Kirklees Council Planning & Development Service
PO Box B93, Civic Centre 3, Off Market Street, Huddersfield, HD1 2JR

Your reference: 2021/94239 and 121, Slaithwaite Road, Meltham, Holmfirth, HD9 5PW.

Drawing Title:
Elevations

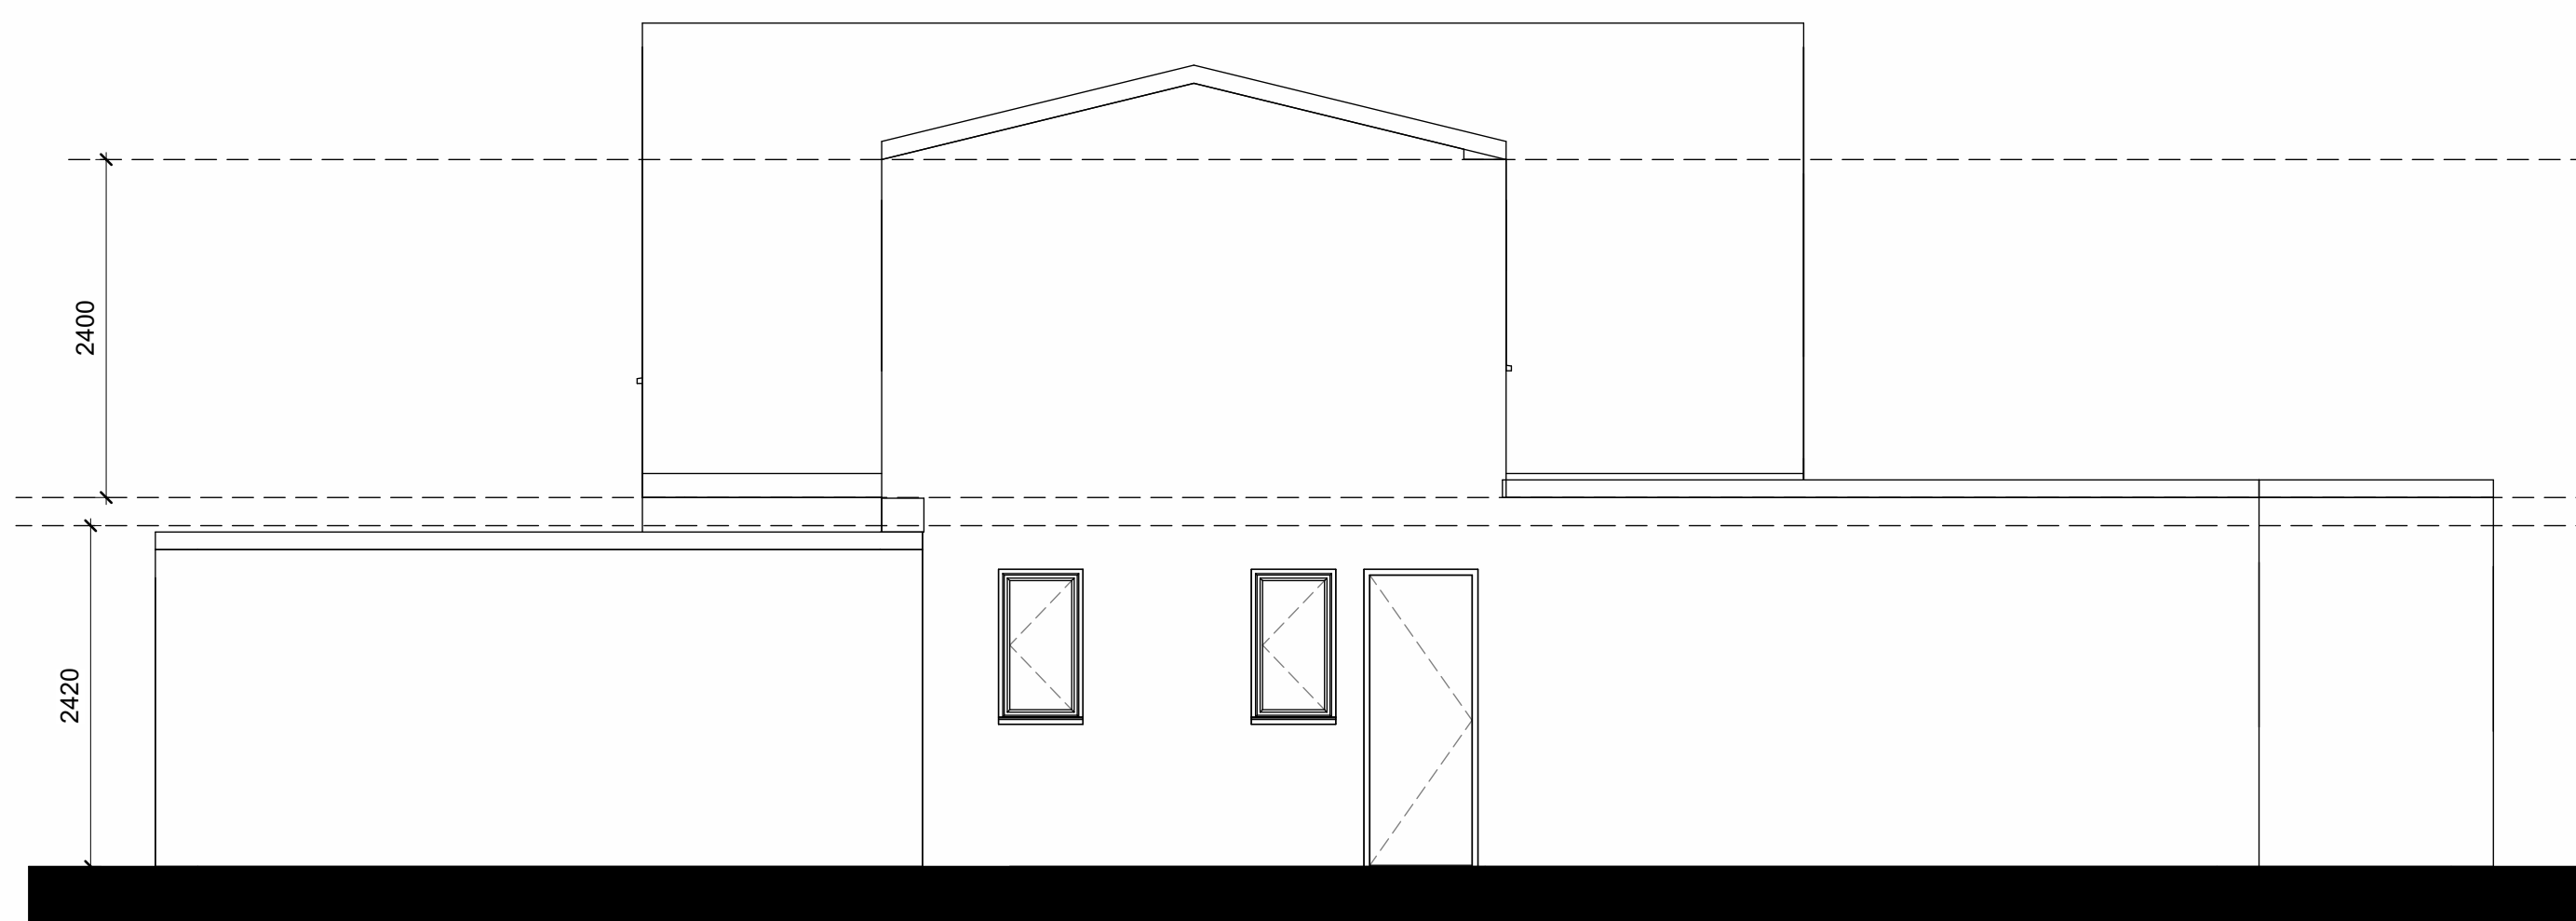
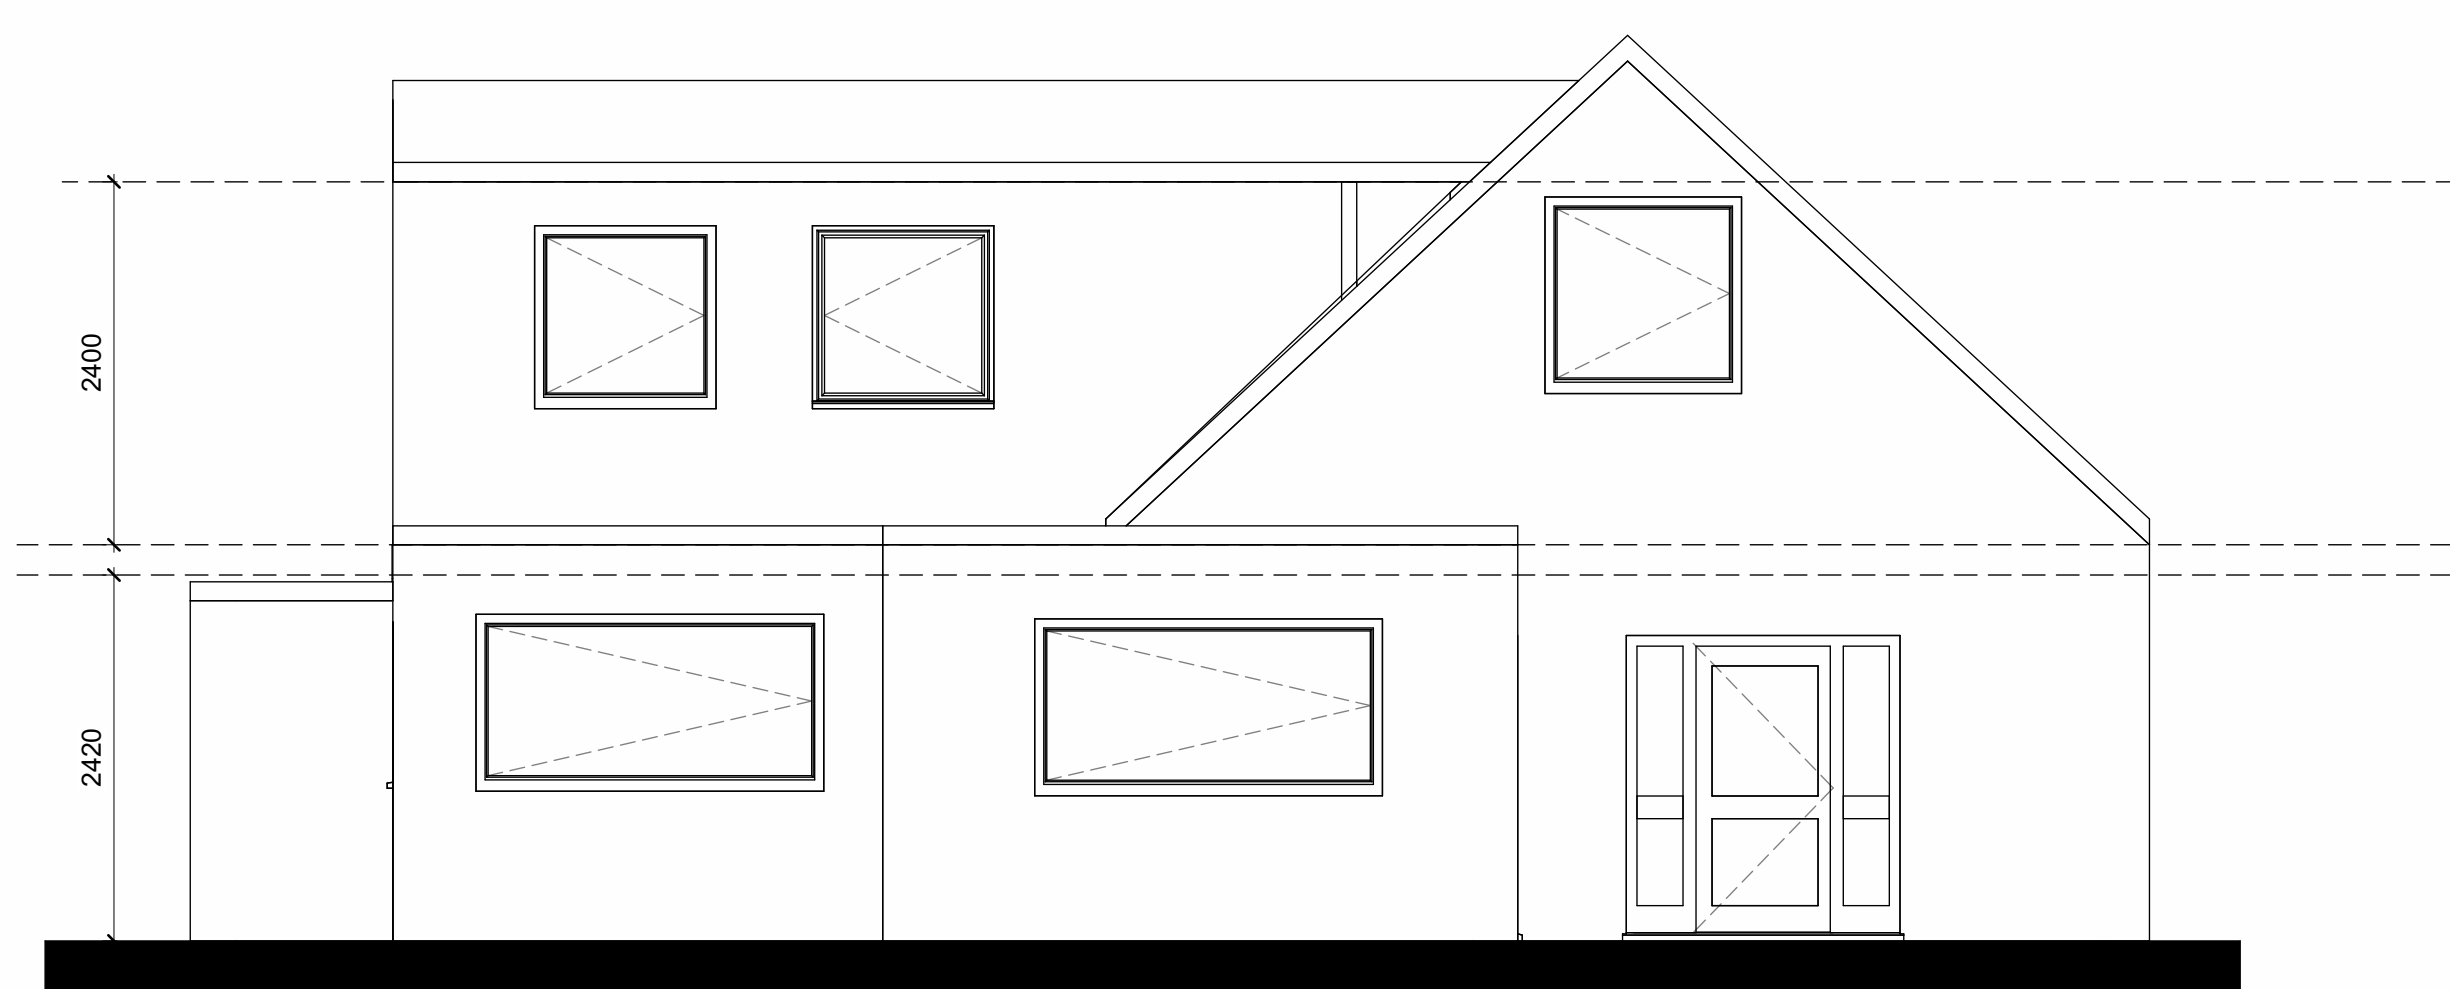
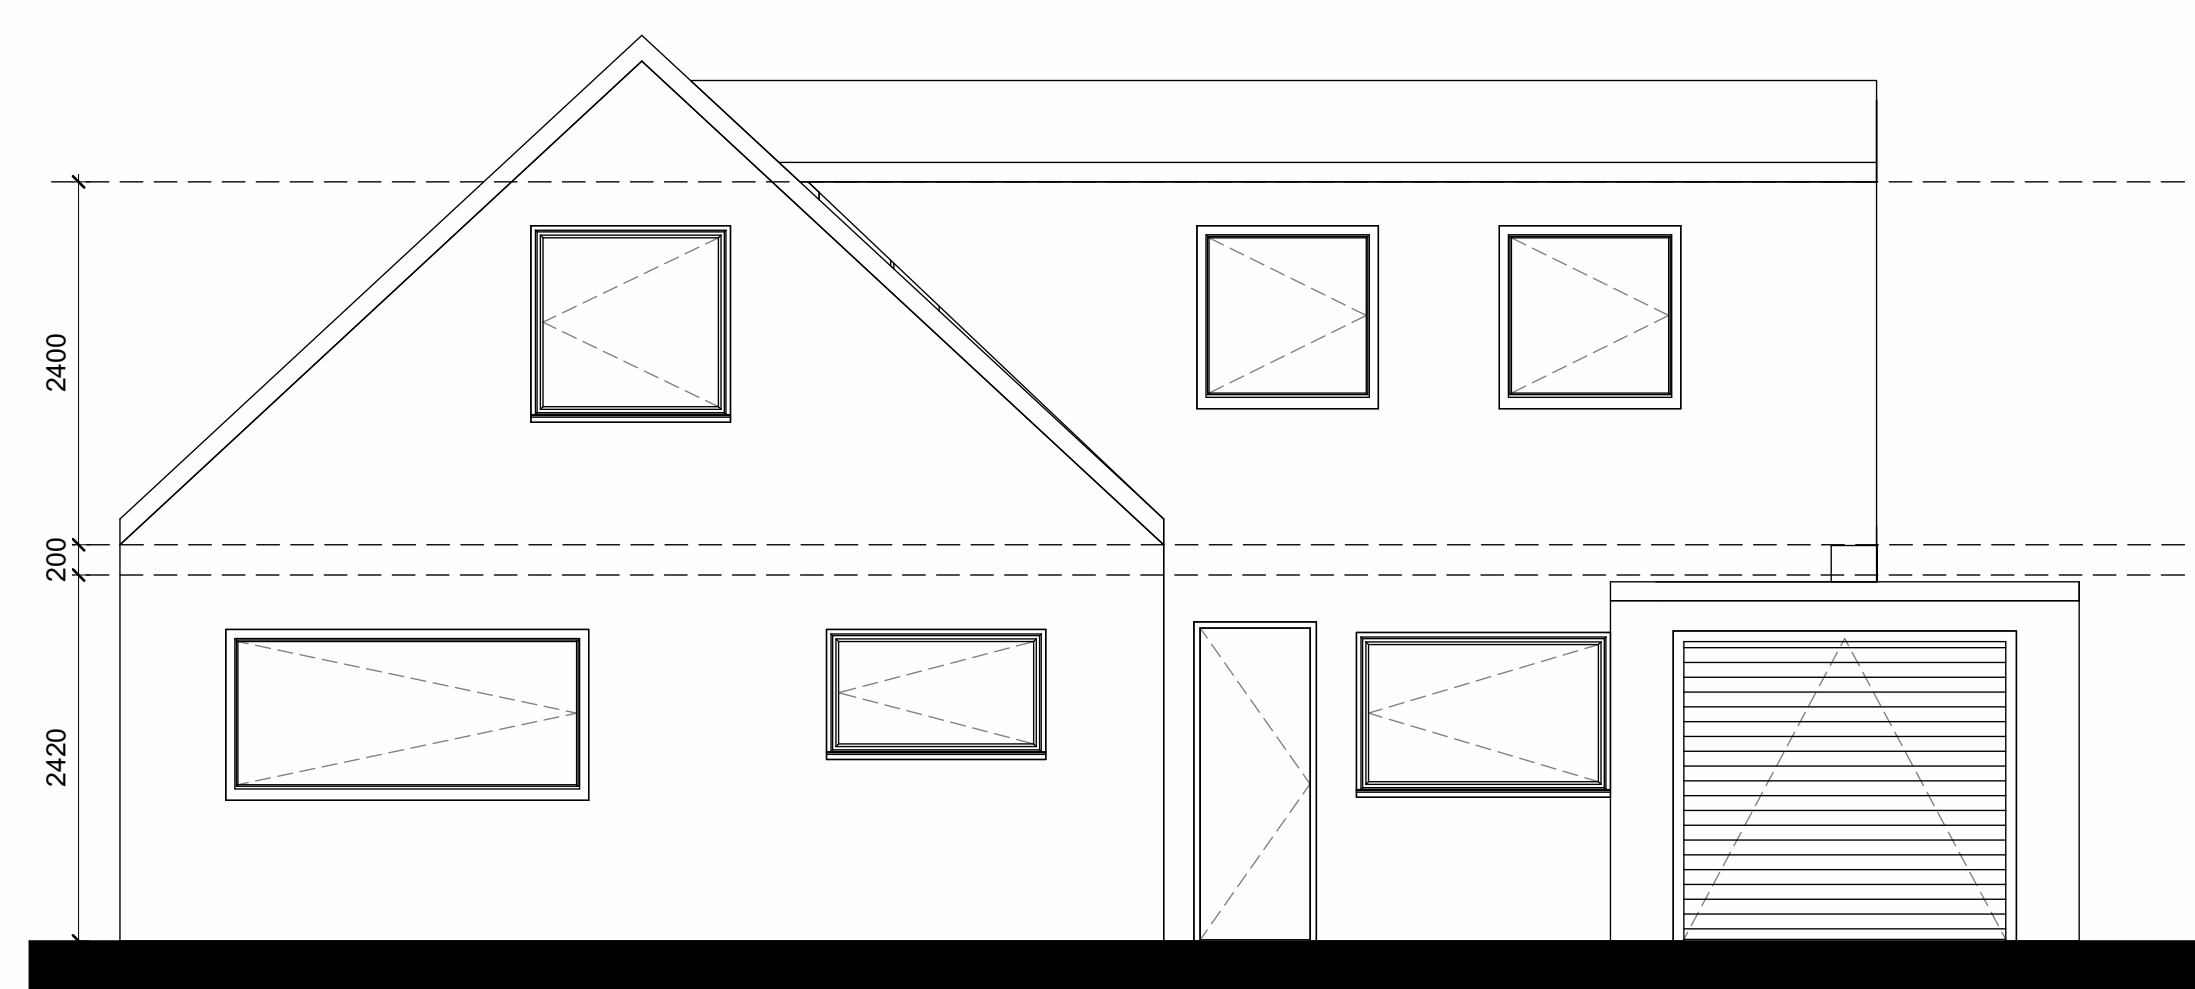
- 2) I would welcome a 3D view of the proposed elevations of the building. I note that one was provided with the original planning application 2021/93100.
